Re: Application ID: 2013-058 120 Veranda Street

We are in receipt of the staff comments relating to the Level 3 Development Review Application and have the following responses:

Comments Submitted by: Shukria Wiar/Planning on 3/21/2013

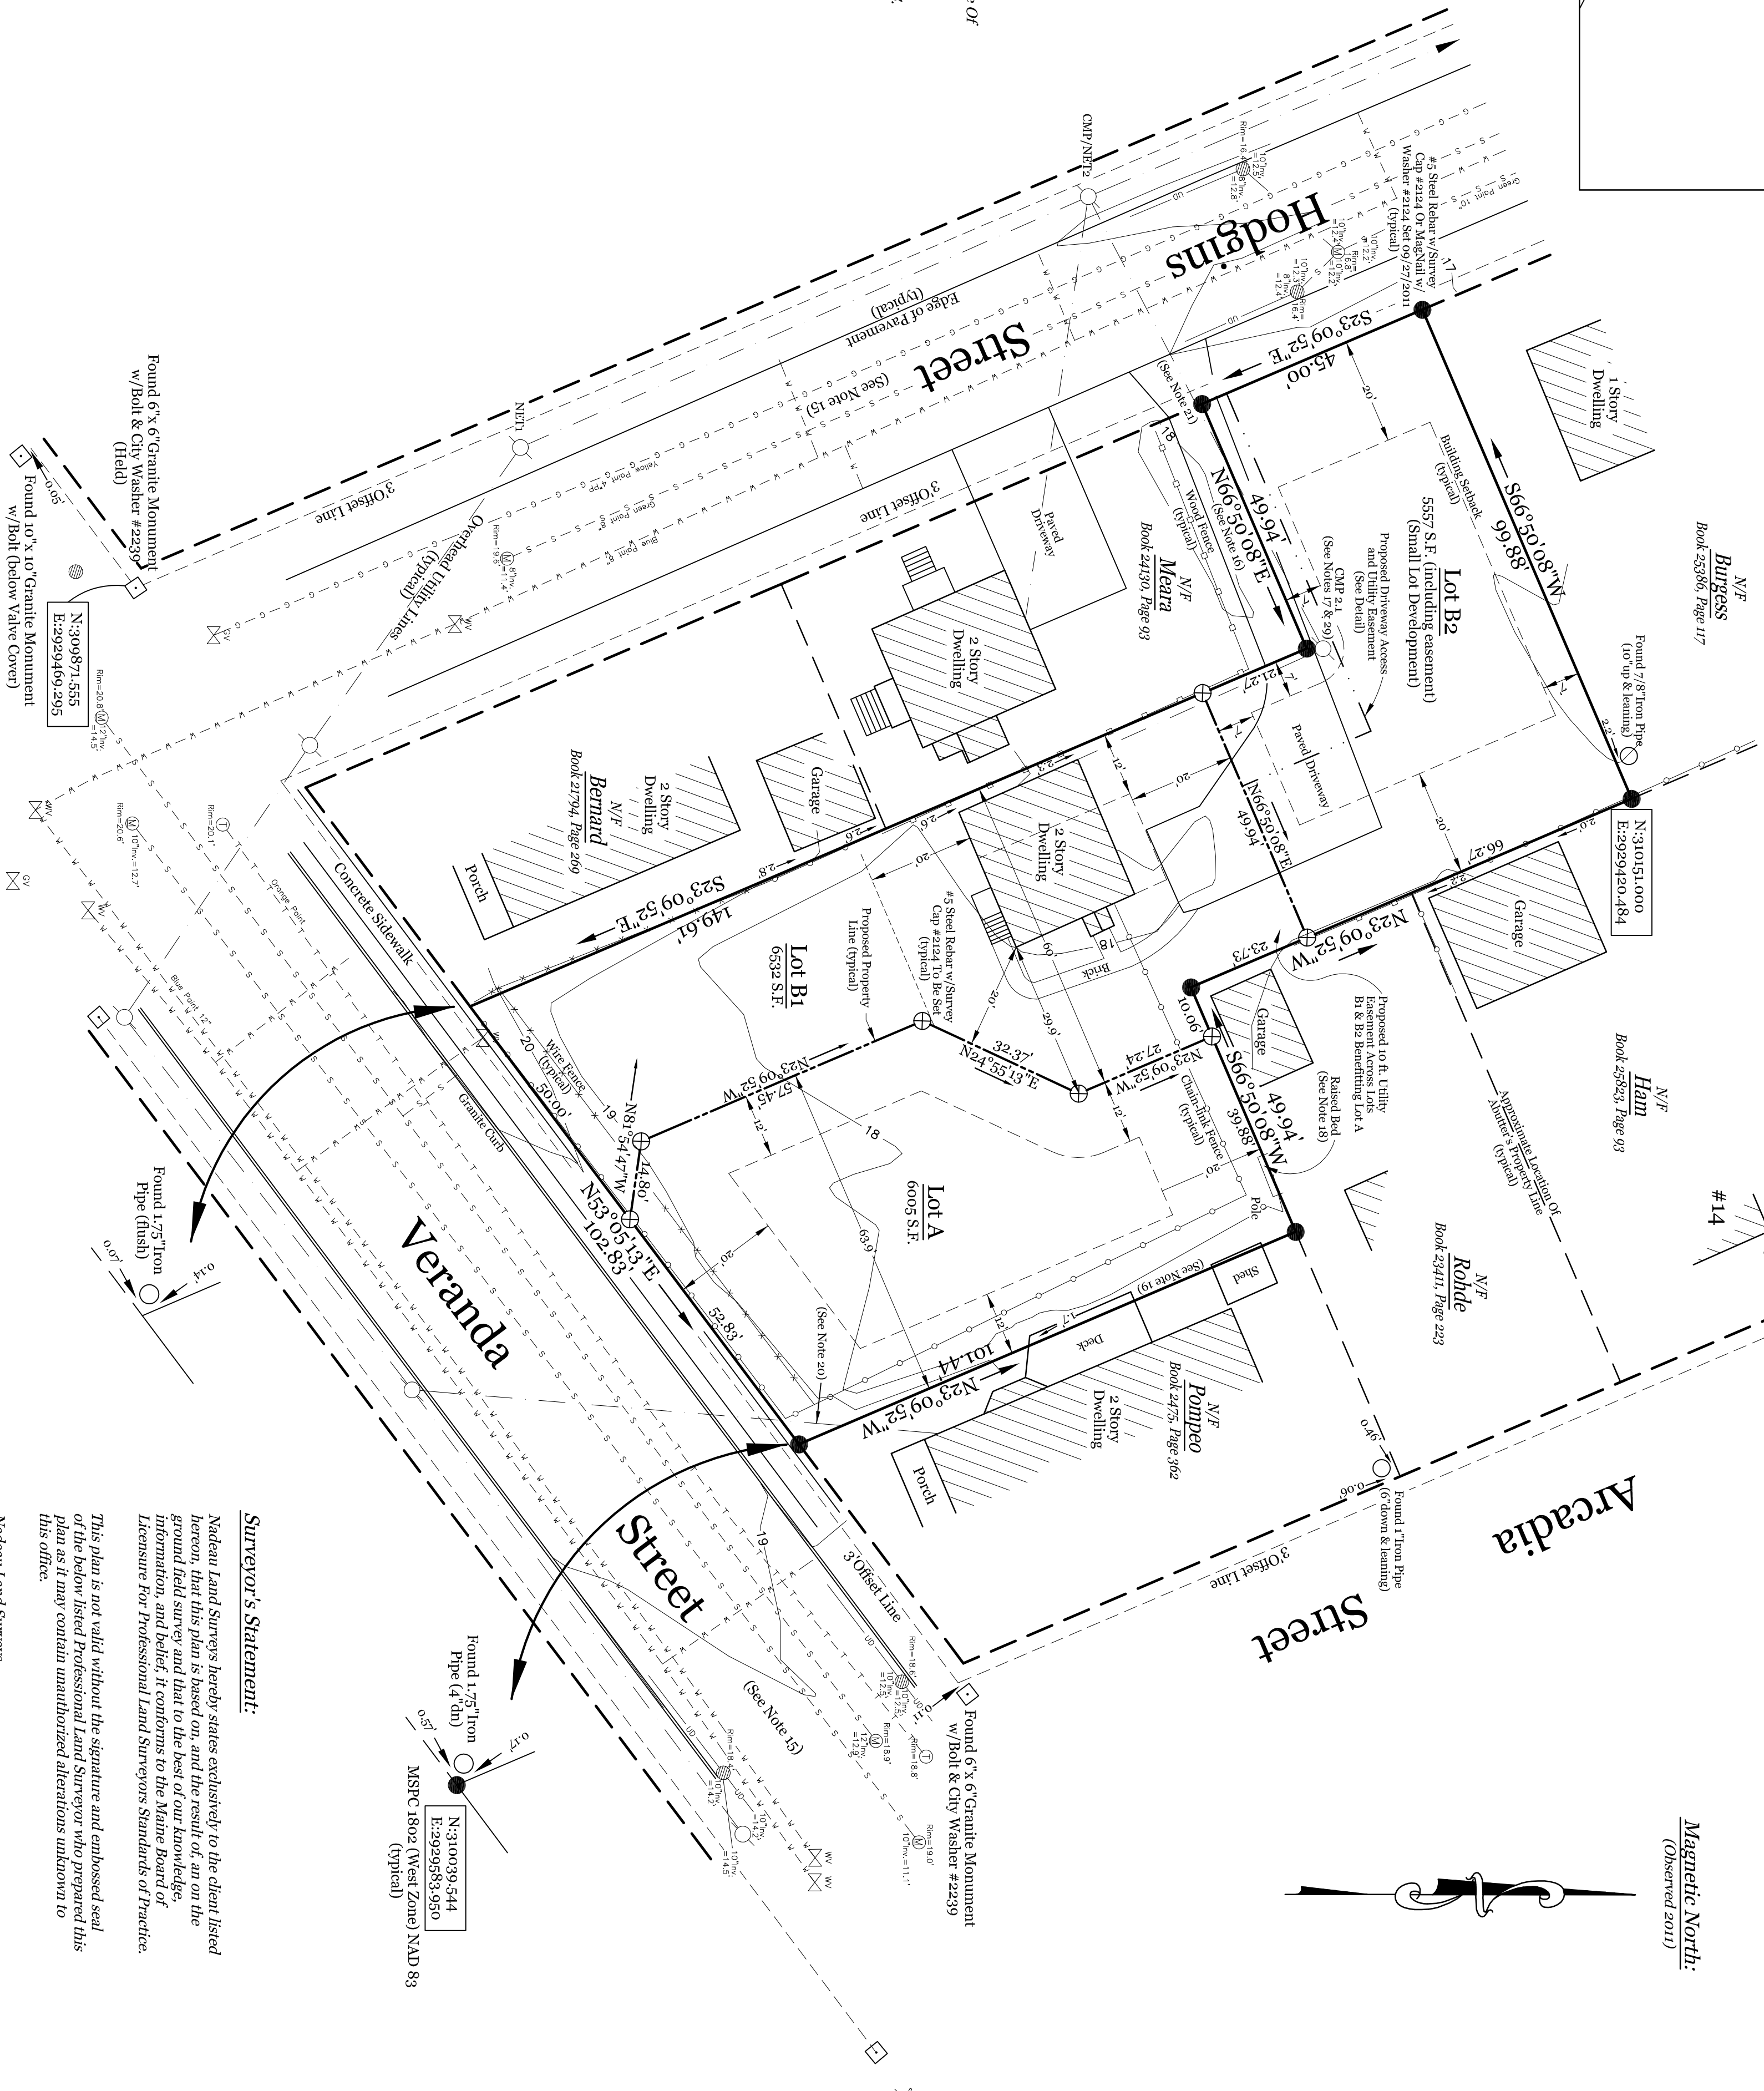
- a. *The plat needs to state that Lot B2 is restricted only to a single family lot and Lot A could be a two-family. As currently proposed B1 does not meet zoning requirements for a duplex and therefore has to be single family home.*

- b. *The applicant is proposing a sidewalk along Hodgins Street, please show on the plat.*

3. *The plan is showing overhead utilities for the two proposed houses, all utility lines must be placed underground.*

- 1. This subdivision did receive a determination letter from me. The request for a subdivision review is for 3 lots which is correct. However, I believe that 4 potential dwellings should be part of the subdivision review. Lot "A", one of the new lots created using the regular R-5 zone requirements, can be developed as a two family by right. It would be correct at this time to include lot "A" as a two unit development. If that is not done now and the new owner of the property wants to put in a two unit and the PB only approved it as a one unit, the new owner would need to return to the Board. Better to include it now instead of bringing it back in 18 months.*

- 2. Please note that lot B1 is an existing single family dwelling. It is fairly small, and I cannot see the availability to put on an addition for a 2nd dwelling unit. It is reasonable for this lot to only be reviewed as a single family dwelling.*

- 4. On Lot "A" where the generic building is placed, violates the regular R-5 minimum lot width requirement. The regular R-5 zone requirements state there shall be a minimum of 60 foot for a lot width where a building is place on a lot. The sketch should be revised to show that all regular R-5 zone requirements can be met. This will help eliminate any misunderstandings from a future purchaser of the land who will want to build on the lot and assume a building can be placed where it cannot.*

Response: The Plat has been changed to note this comment.

Response: The Applicant has requested a waiver from the Subdivision Standards to exclude the curbing and sidewalk from the project- see attached letter. If the Board does not approve the waiver it will be added to the Plat.

Response: A note has been added to the Subdivision Plan indicating that all proposed utilities will be placed underground. Based on meetings and conversations with CPM, we are proposing that the service to Lot B1 remain overhead, Lot B2 is underground from the existing power pole and lot A will be served by extending a pole across Veranda Street and running underground from that pole to the proposed building.

Response: We have revised the notes on the Subdivision Plat to indicate that Lot A can be developed as a two-unit development.

Response: We agree and have placed a note on the Plat that it can only be developed as a single family lot.

Response: We have revised the generic building footprint to show it is meets all regular R-5 Zone requirements.

SITE UTILITIES & GRADING PLAN
PROPOSED SUBDIVISION
 120 VERANDA STREET
 OWNER: STEVEN E. & ROBERTA S. COPE
 172 CONCORD STREET
 PORTLAND, MAINE 04103

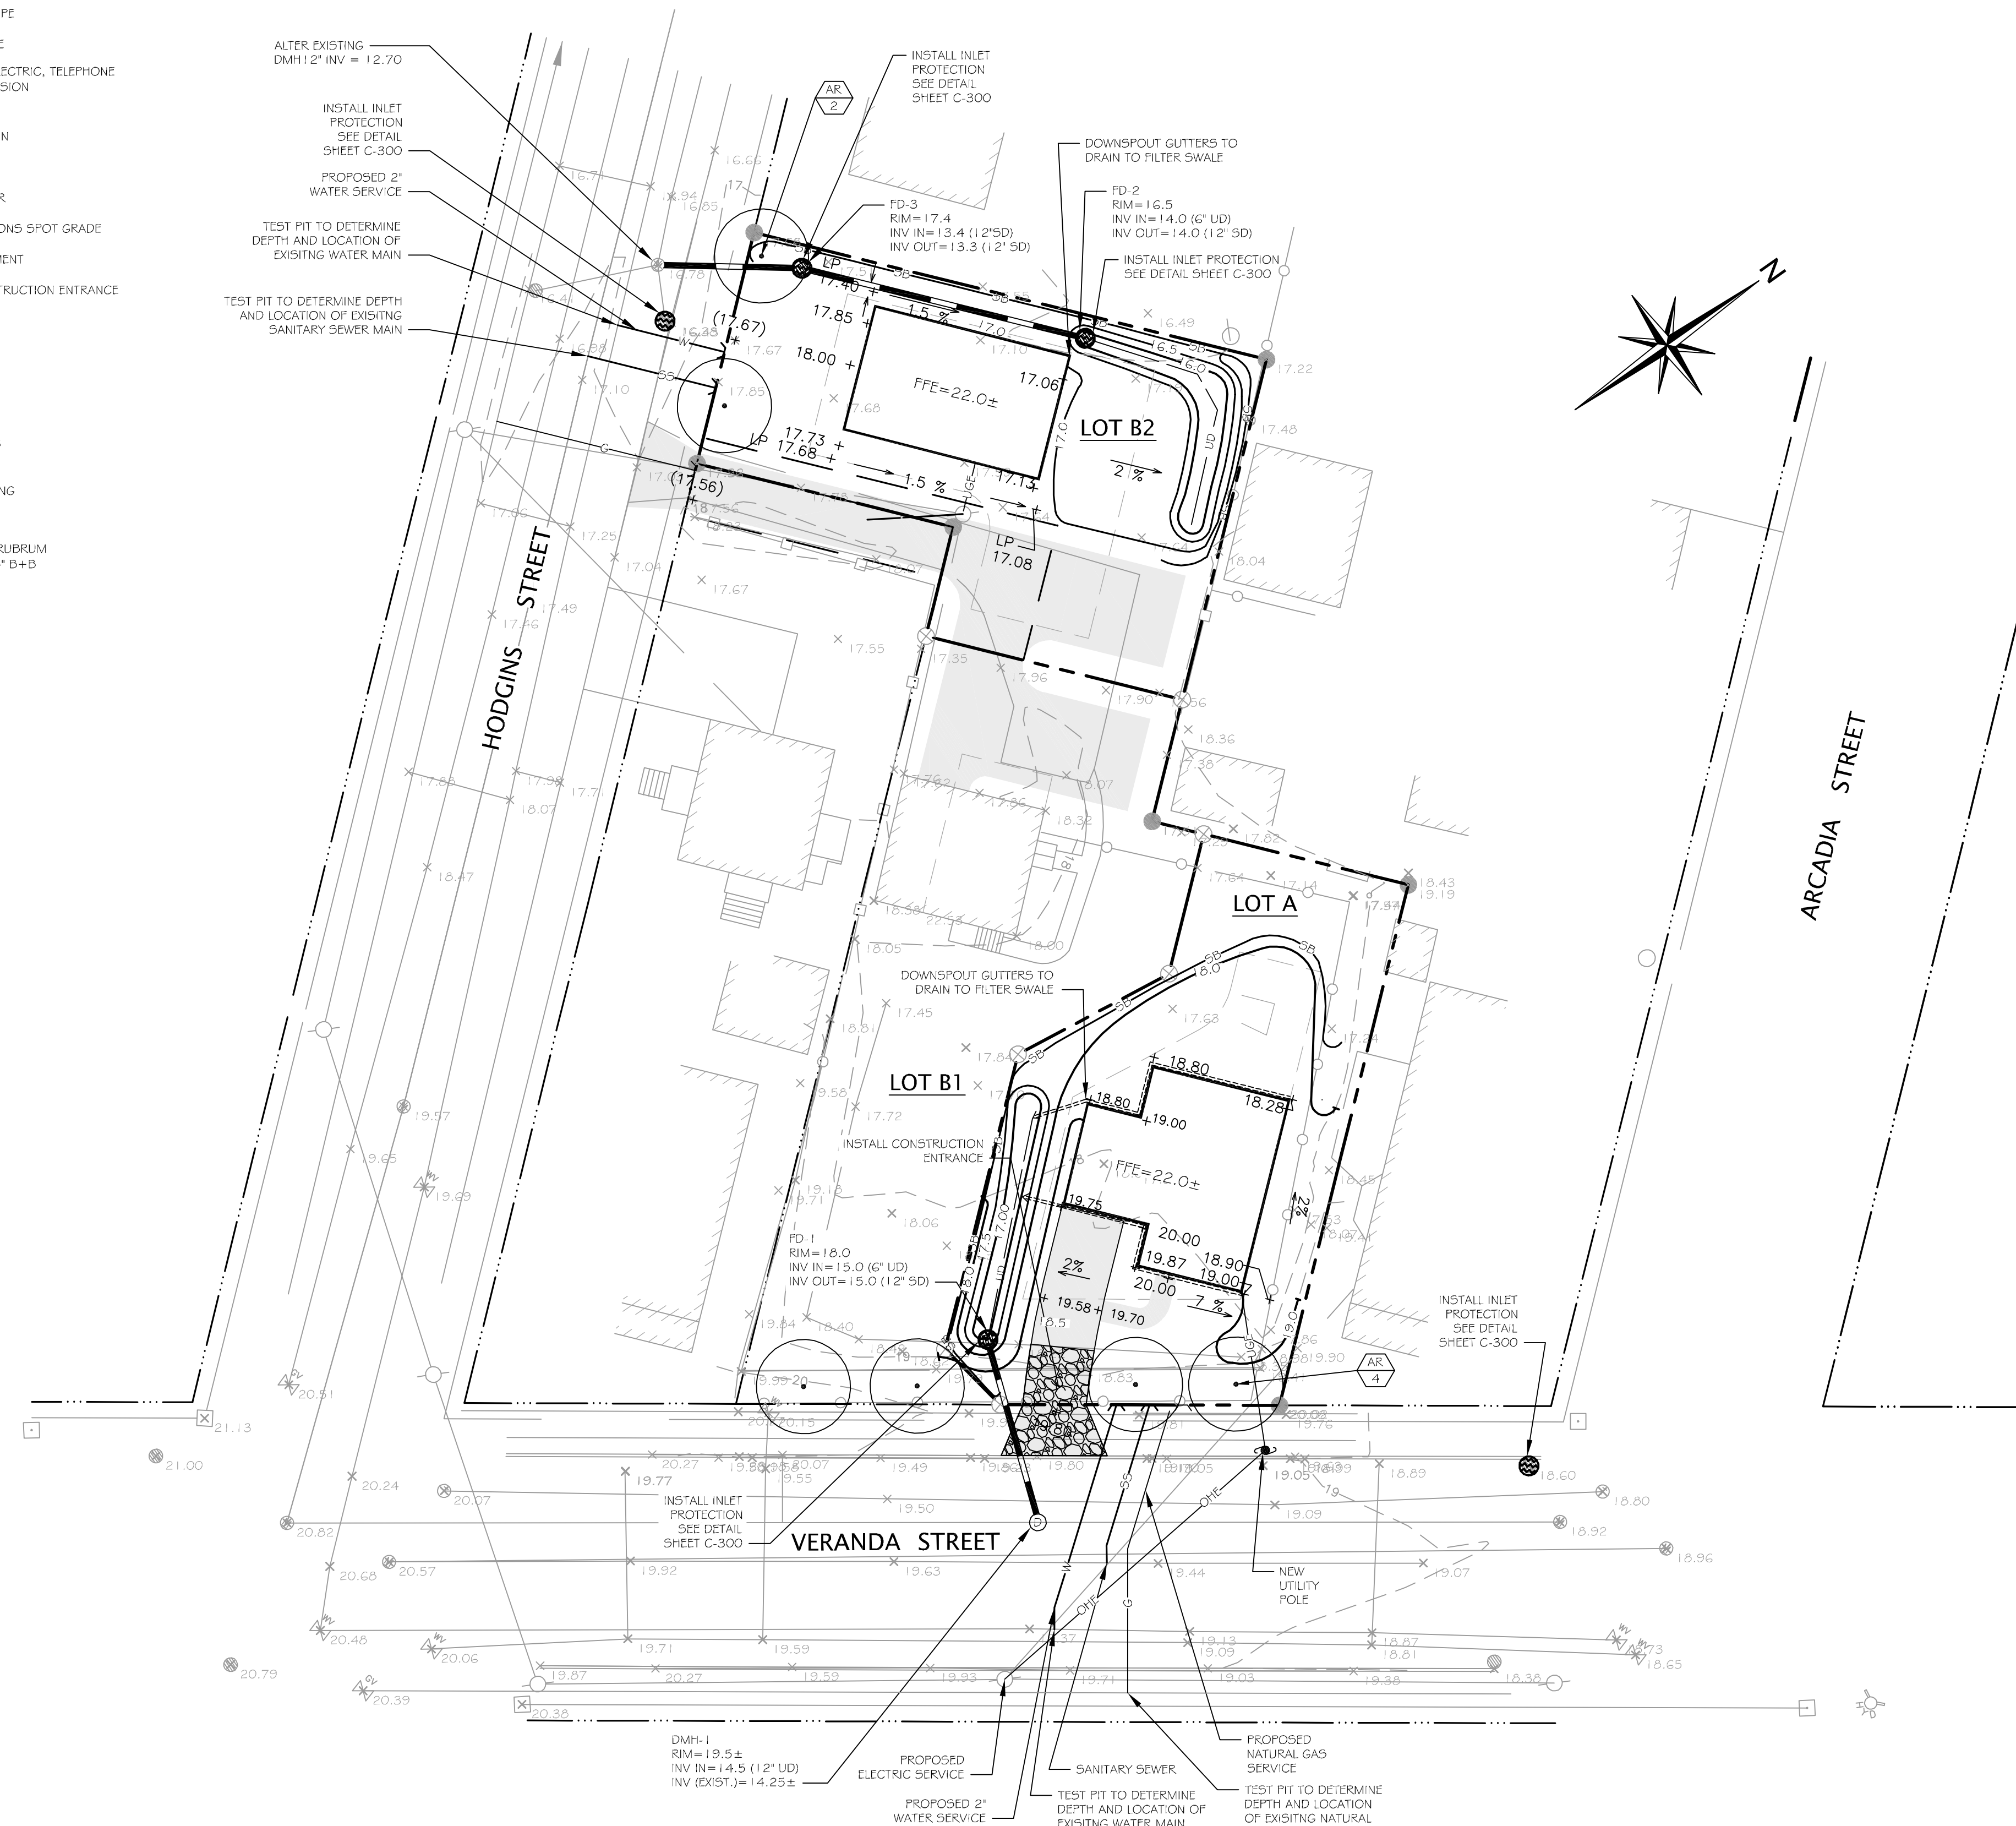
6. *The Grading Plan will need to show the grading around the proposed houses so that staff can review how the stormwater will be drained into the rain gardens. Please provide more details on the grading.*

3. *Portland standards require a three foot sump on all catch basin discharging to the City's stormwater drainage system. Please provide for all proposed field drainage structures with a three foot sump.*

4. *Storm drain pipes are not permitted to be connected into City of Portland catch basins per the City of Portland Technical Manual, Section 2.7.8. The Applicant should propose an alternate means of connecting Lot B2 to Hodgins Street.*

5. *The Applicant should provide more detailed site grading and surface drainage information on the Site Utilities and Grading Plan (C-100), including elaborating on the requirement for the full roof area to discharge to the soil filter systems to ensure that the future lot designs conform with the permitted stormwater treatment strategy.*

Response: The Grading Plan has been revised to include this information.

Response: The detail and plans have been revised to show a 3 foot sump in the bottoms of the proposed catch basins.

Response: The storm drain pipe connecting Lot B-2 to Hodgins Street has been revised to connect at the SMH in Hodgins Street rather than into the catchbasin. This is shown on the revised Grading and Utility Plan.

Response: Additional site grading, spot elevations, and notes requiring full roof collection and discharge into the soil filters have been added to the Grading and Drainage Plans.

5 BITUMINOUS DRIVEWAY APRON
NOT TO SCALE

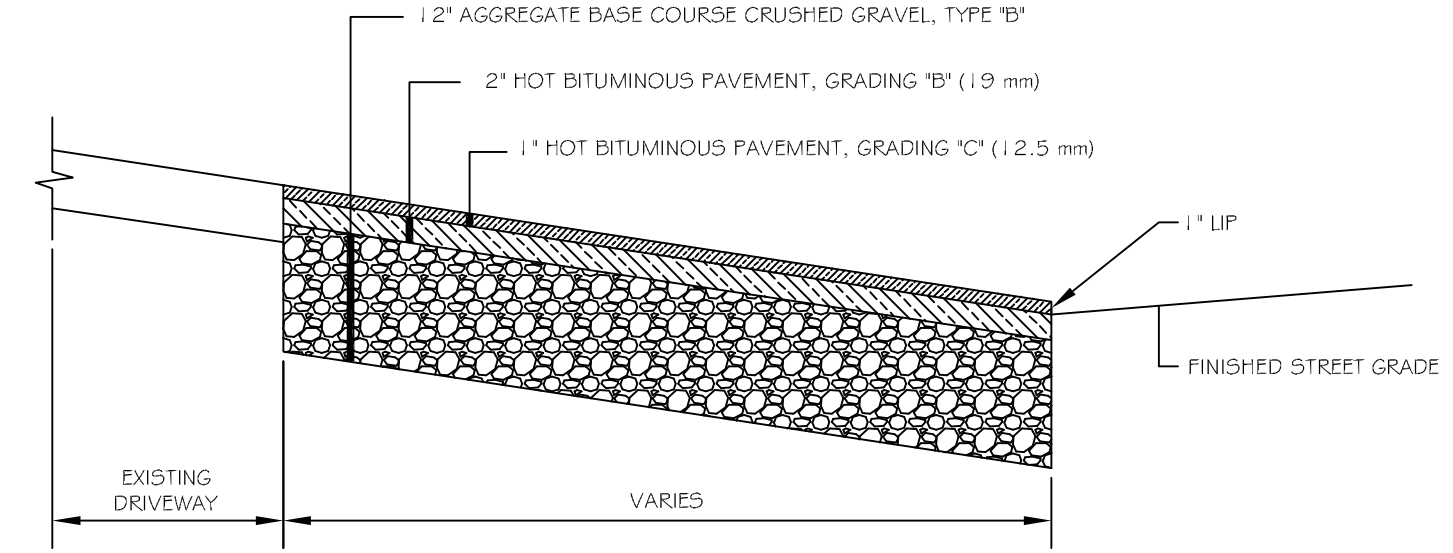
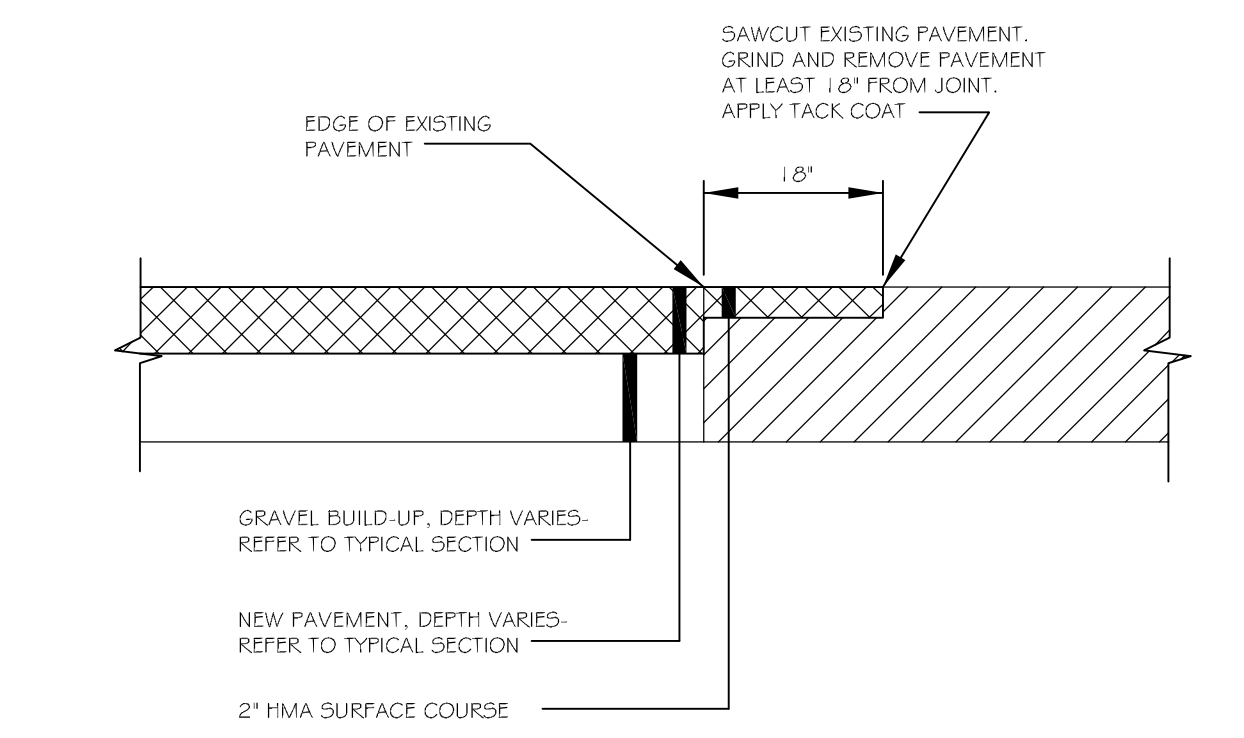
3. *The Applicant should provide a Bituminous Driveway Apron Cross-Section Detail in accordance with Figure I-13 of the City of Portland Technical Manual for work within the City Right-of-Way.*

Response: A detail for the typical driveway Apron Cross Section will be added to the Plan.
